TfNSW Reference: SYD24/01526/01
DPHI Reference: SSD-50972718

**ADVICE ON EXHIBITION OF ENVIRONMENTAL IMPACT STATEMENT (EIS)
WALLGROVE ROAD BUSINESS HUB (SSD-50972718)
97-151 WALLGROVE ROAD, CECIL PARK**

TAB A – TfNSW advisory comments and suggested Development Consent conditions

Project	Wallgrove Business Hub TTS
Title	Alternative Access Arrangement Concept Plan

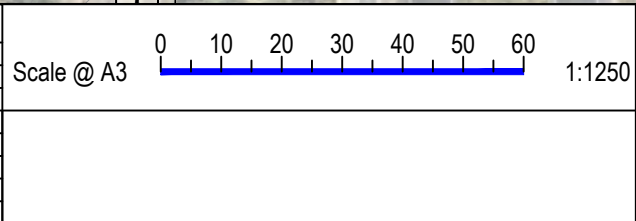
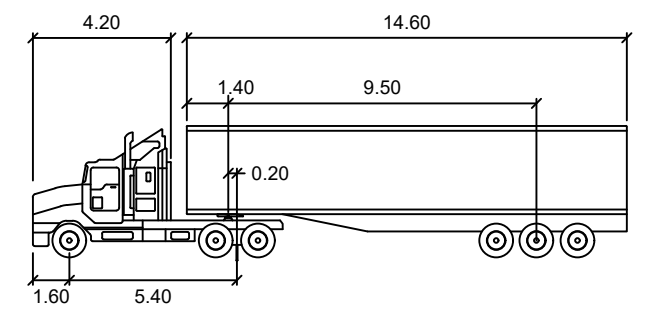
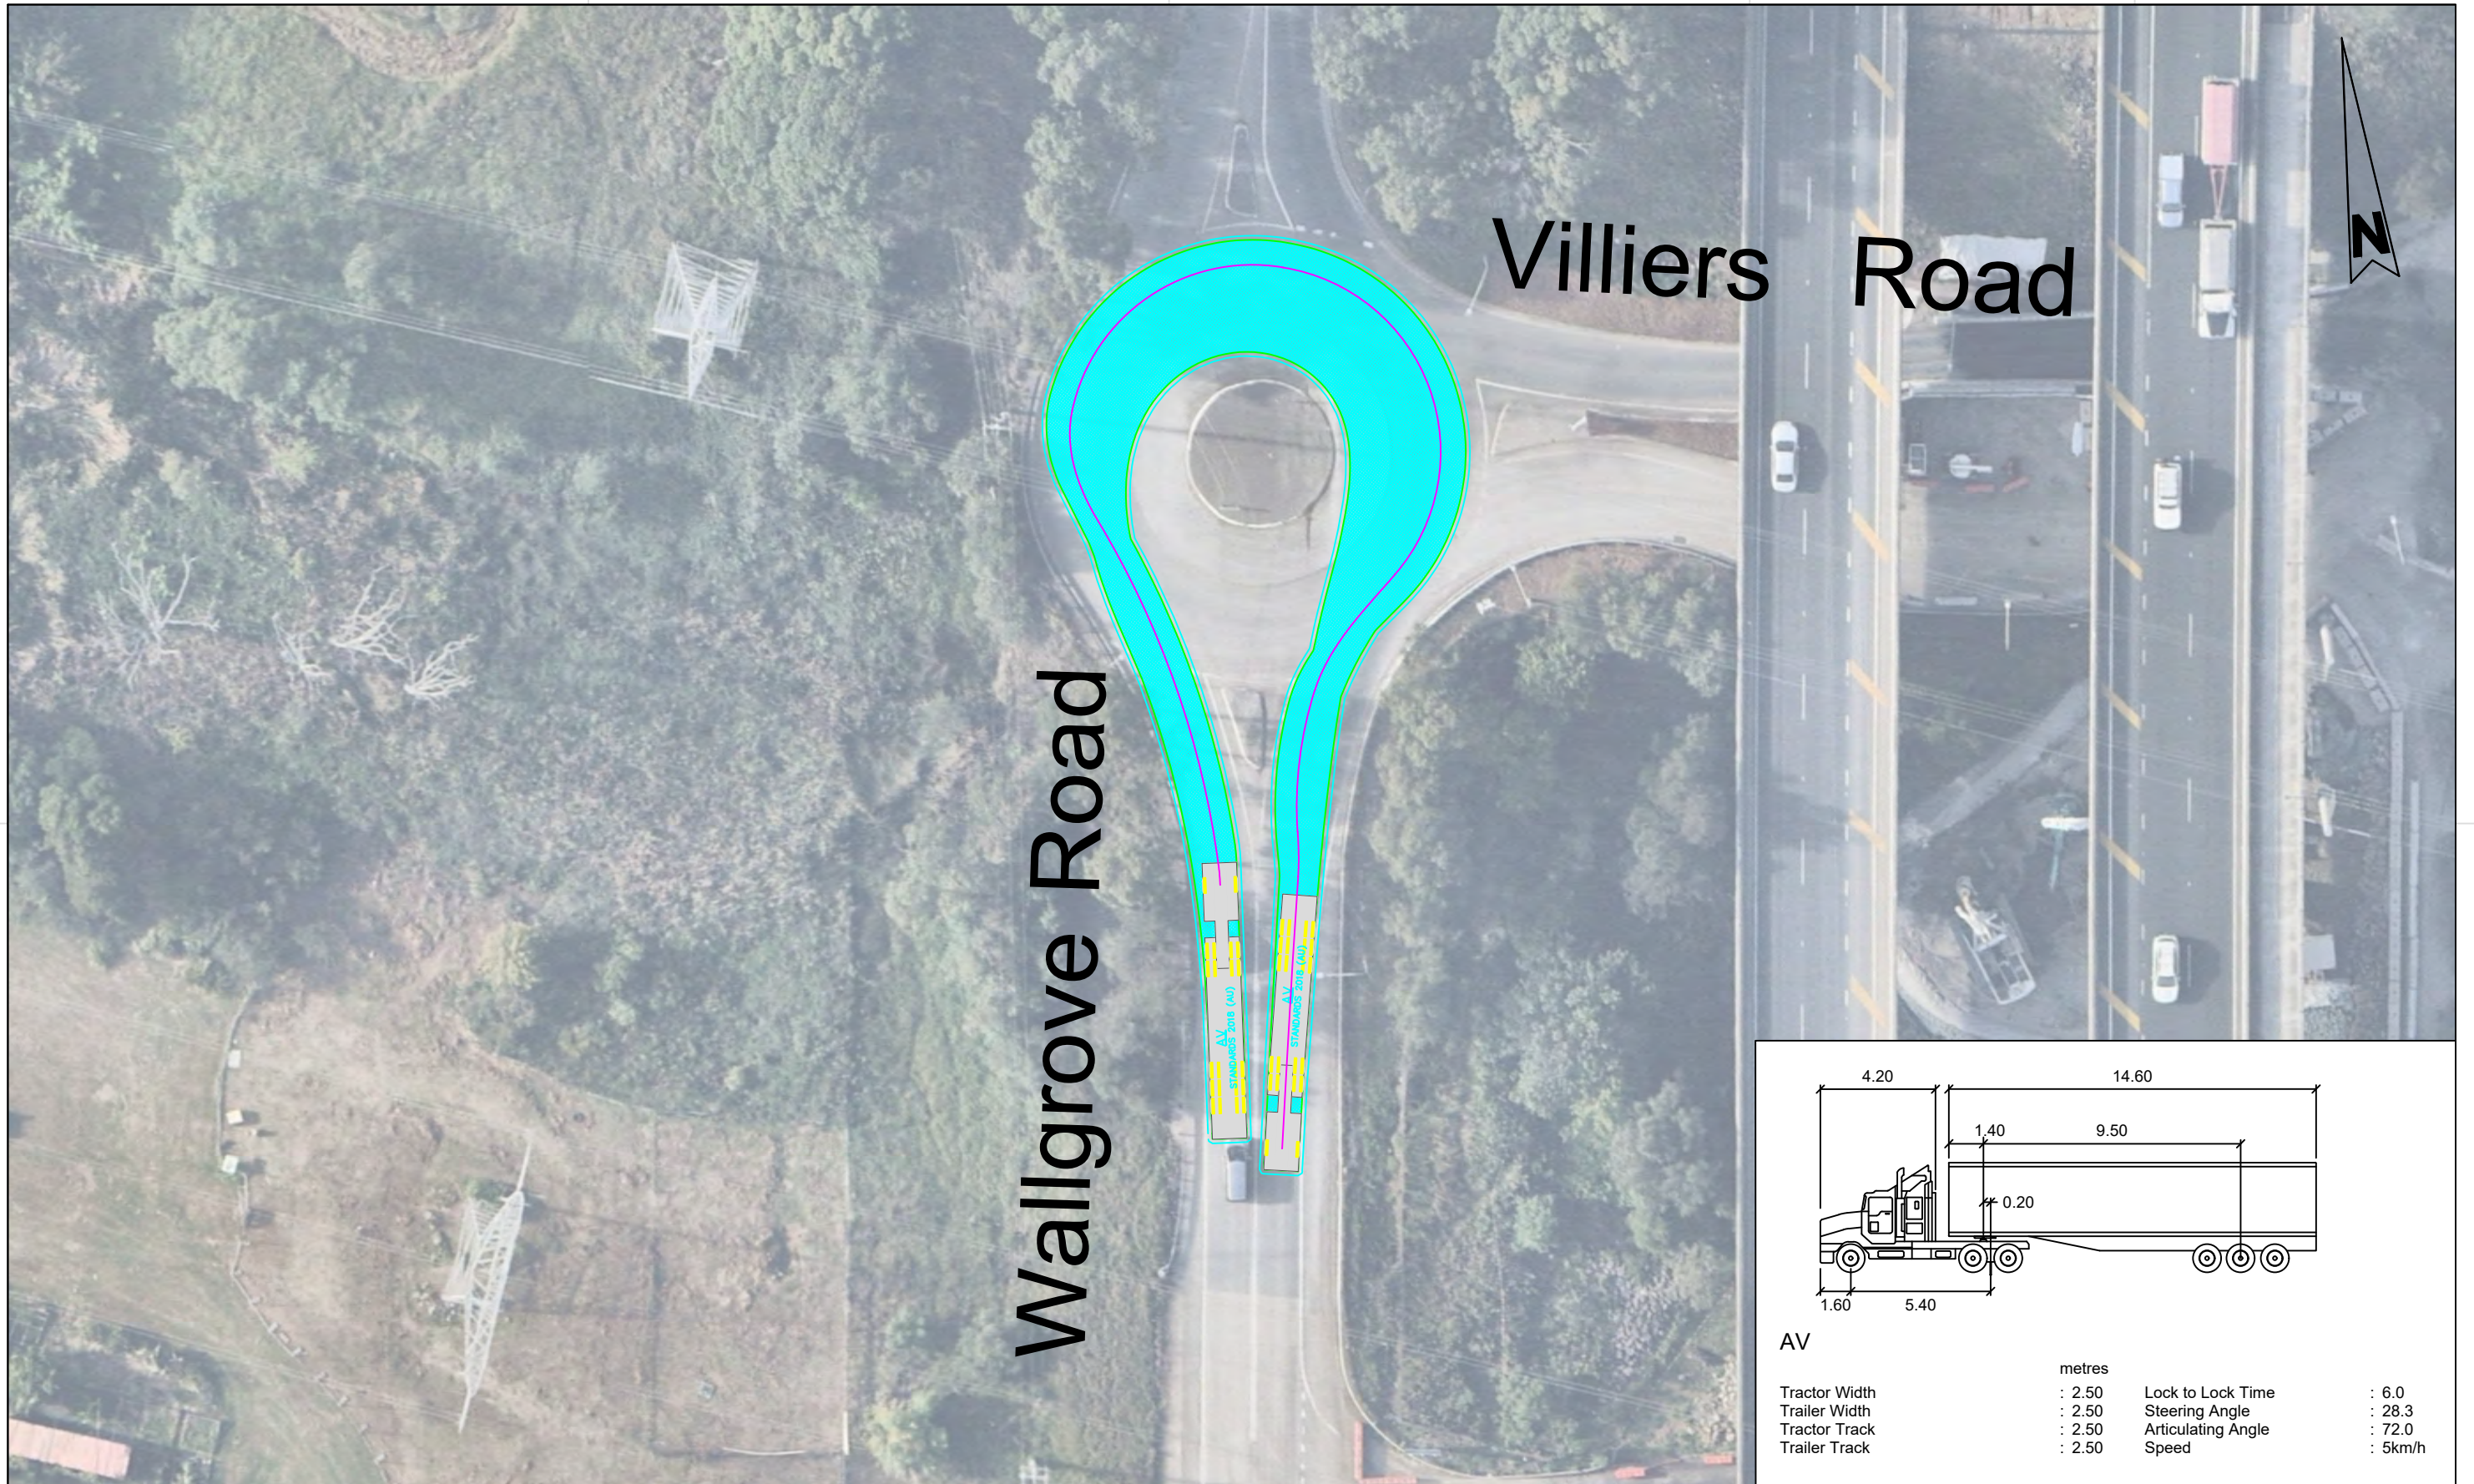
TfNSW notes that a new intersection is proposed to Wallgrove Road (**classified road**) to include the provision of northbound deceleration lane and geometrically channelised 'left-in / left-out' arrangement and a triangular traffic island to support. TfNSW supports the Applicant's recommendation that no acceleration lane is to be provided on Wallgrove Road.

As part of any Planning Approval issued, the Applicant should be conditioned to obtain TfNSW concurrence under section 138 of the *Roads Act, 1993* for any civil works on Wallgrove Road and enter into a Works Authorisation Deed (**WAD**) with TfNSW for the proposed works.

The access is to be designed to Austroads standards with consideration to the exit ramps from M12 Motorway to Wallgrove Road, access/leasing arrangements with TfNSW and sight distances on the realigned Wallgrove Road to the south of the development.
